Responses to Comments

Drainage Report Comments

Final Plat Comments

PRE-DEVELOPMENT DESIGN POINT SUMMARY TABLE							
DESIGN POINT	CONTRIBUTING BASINS	AREA (ACRE)	C5	C100	TIME OF CONCENTRATION (TC)	Q5 (CFS)	Q100 (CFS)
DP-1	EX-3	1.93	0.08	0.35	21	0.51	4.85
DP-2	OS1, OS2, EX-1, EX-2	15.60	0.10	0.36	31	4.14	28.09
TOTAL	OS1, OS2, EX-1, EX-2, EX-3	17.53				4.40	30.63

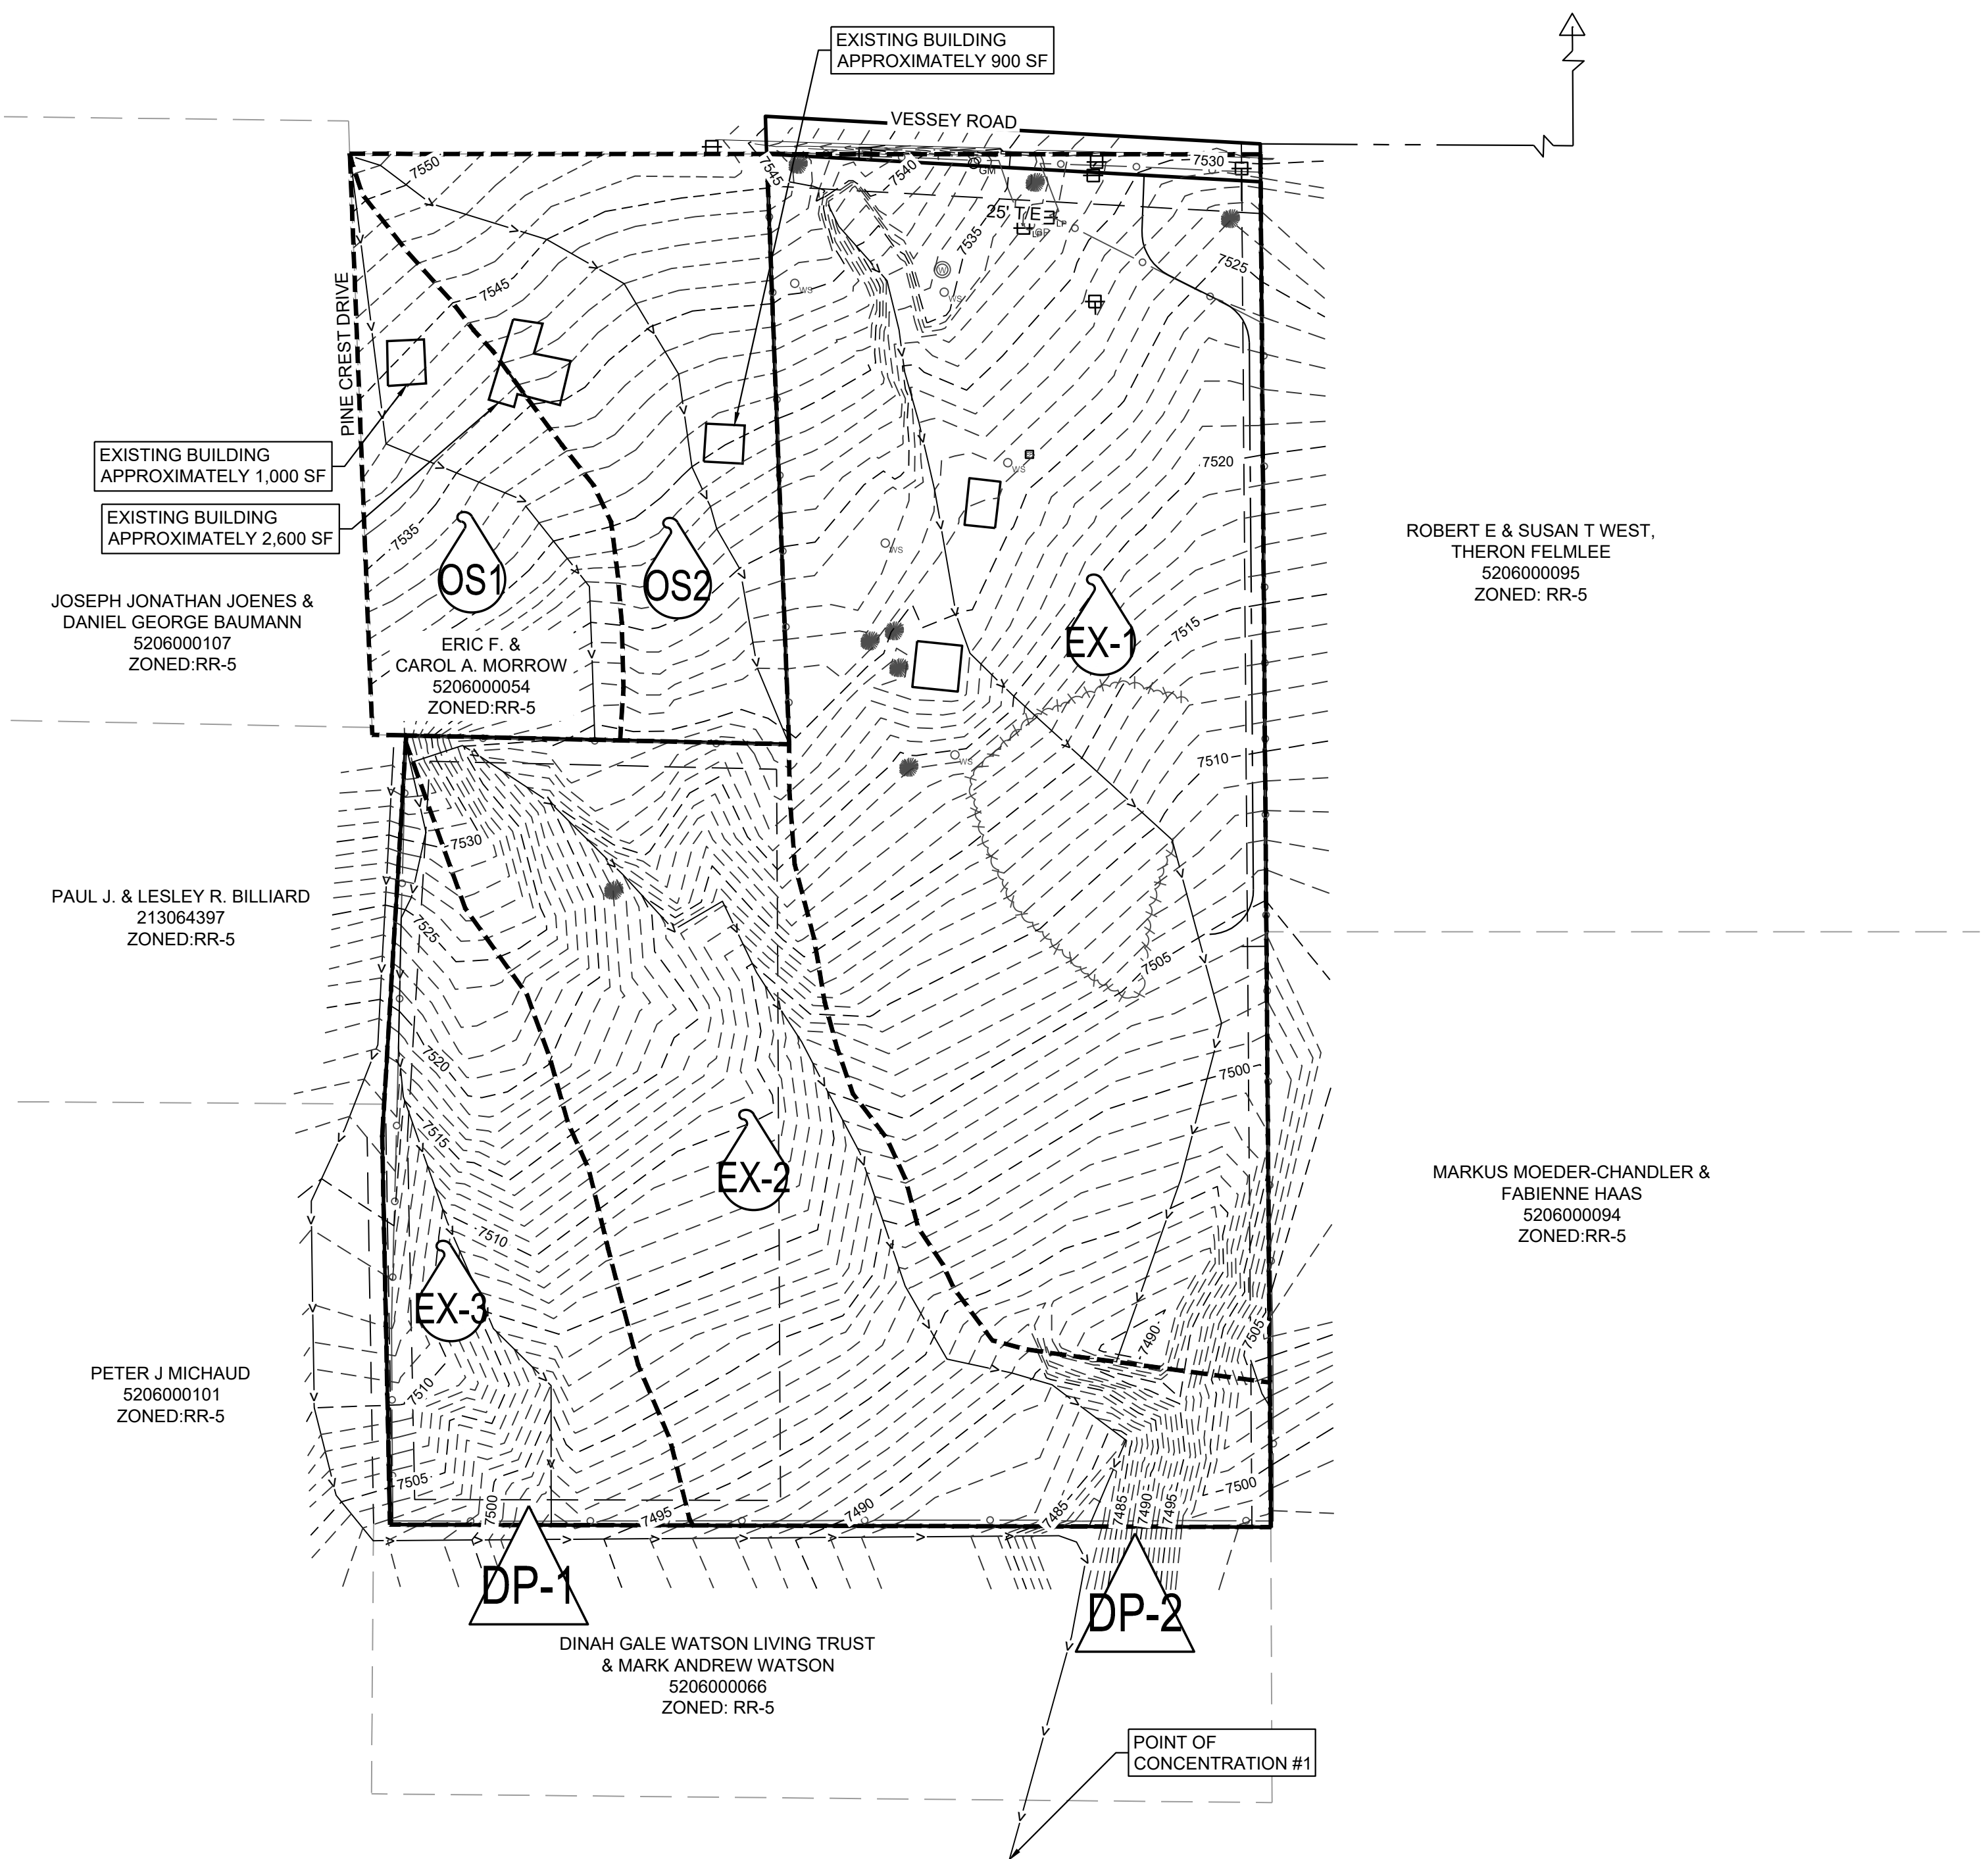
- Add a design point and update the summary table to include the combined flow for both the existing and proposed condition. **Design points added and table added.**

- Add a design point and update the summary table to include the combined flow for both the existing and proposed condition. **Design points added and table added.**

TYPICAL DRIVEWAY CROSS SECTION
NOT TO SCALE

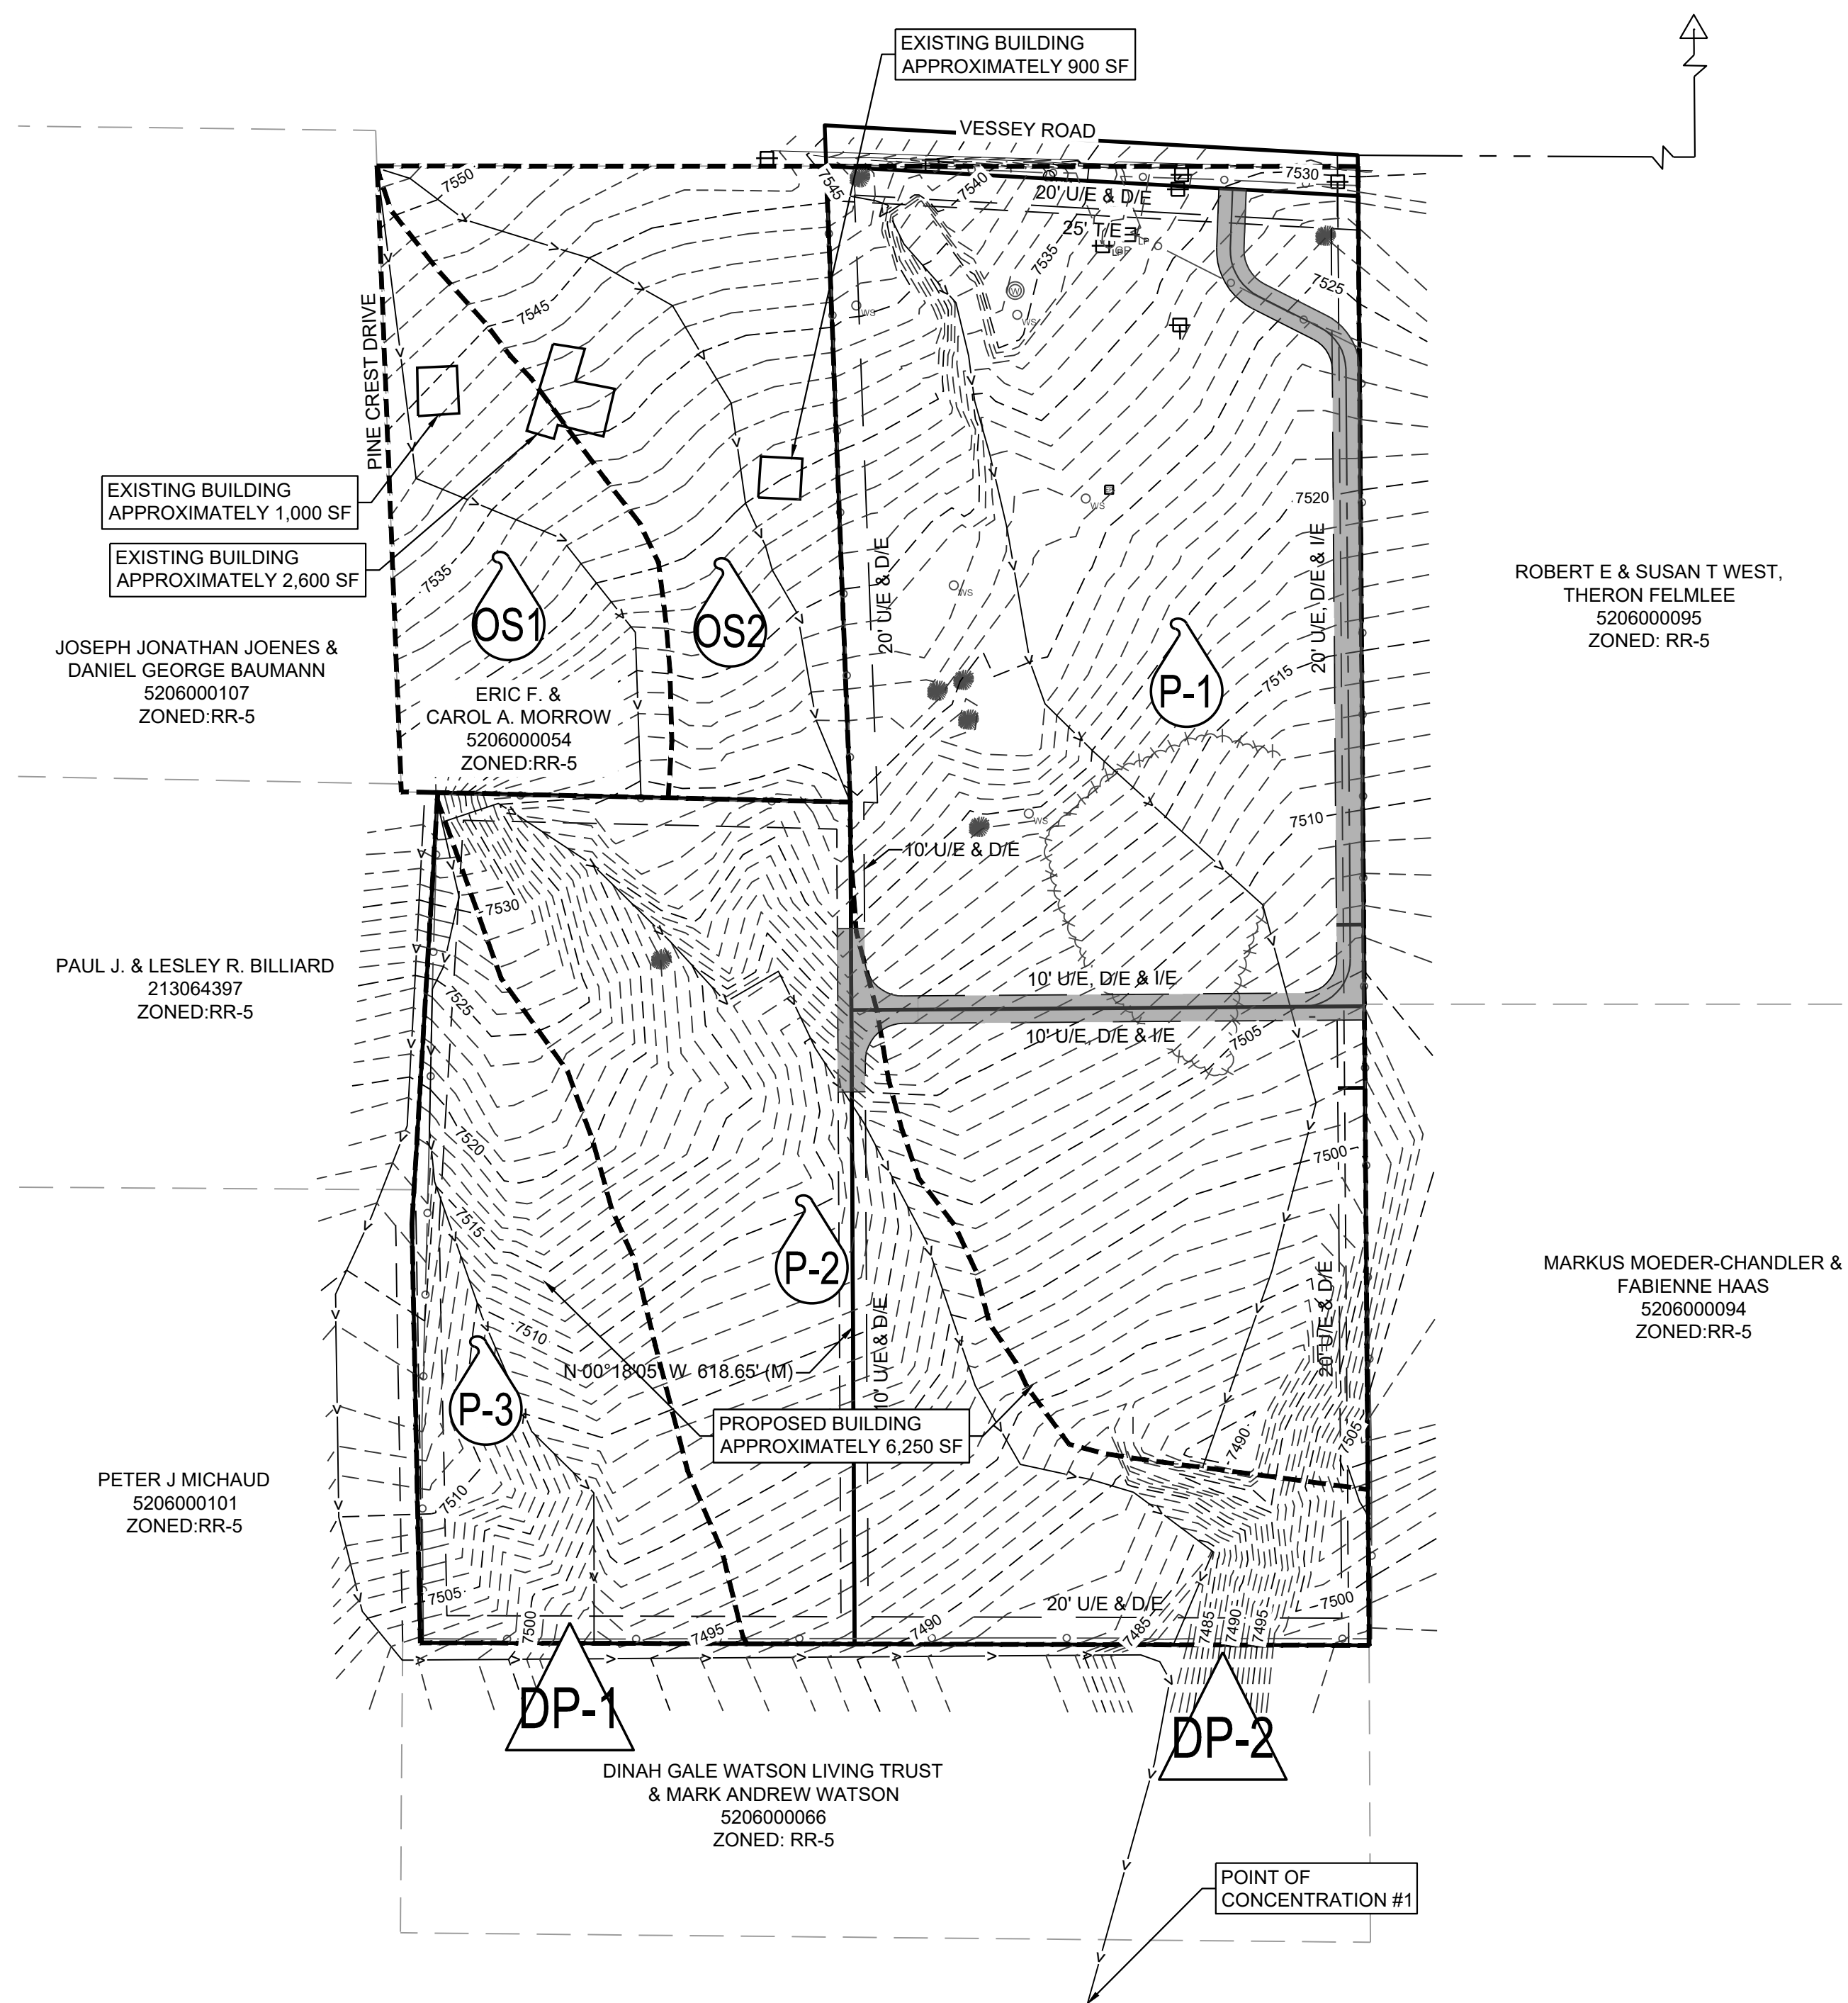
- Provide a typical cross section of the shared driveway.
- Provide contour elevation and/or spot elevation. Existing and proposed contours at 2 feet maximum intervals. For subdivisions involving rural lots greater than 1.0 acre, the maximum interval may be 5 feet where approved. In terrain greater than 10% the intervals should be 10 foot intervals. **Contour labels added.**
